Comments for Planning Application 20/00619/HOU

Application Number: 20/00619/HOU

Address: 225 Havant Road Portsmouth PO6 1DA

Proposal: Construction of dormers to front and rear roofslopes

PROPOSED FRONT ELEVATION

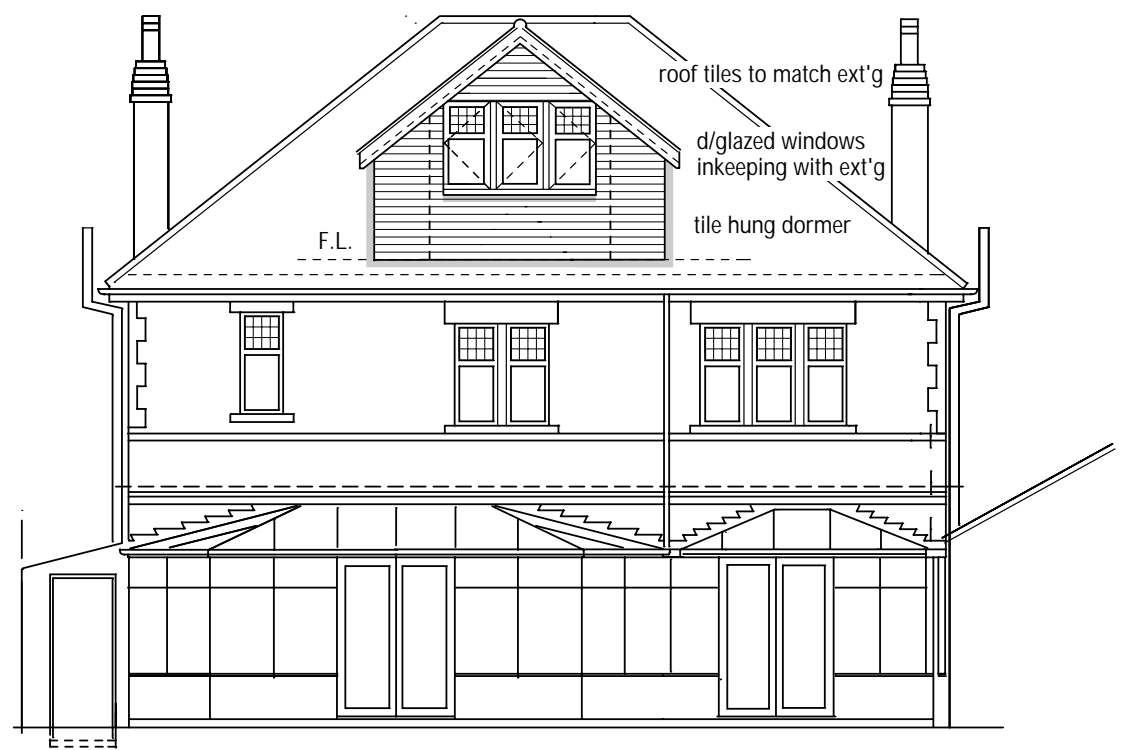
If the permission is granted to construct dormer windows to the front elevation it will seriously infringe upon our privacy.

The property is in an already elevated position compared to our property. If dormer windows are installed there will be a clear view into our private garden living room and bedrooms.

This will take away the only private garden area we have as we are already overlooked by dormer windows to the side of our property.

We would not object to standard velux windows being installed as these do not provide a view unless sticking your head out of the window!
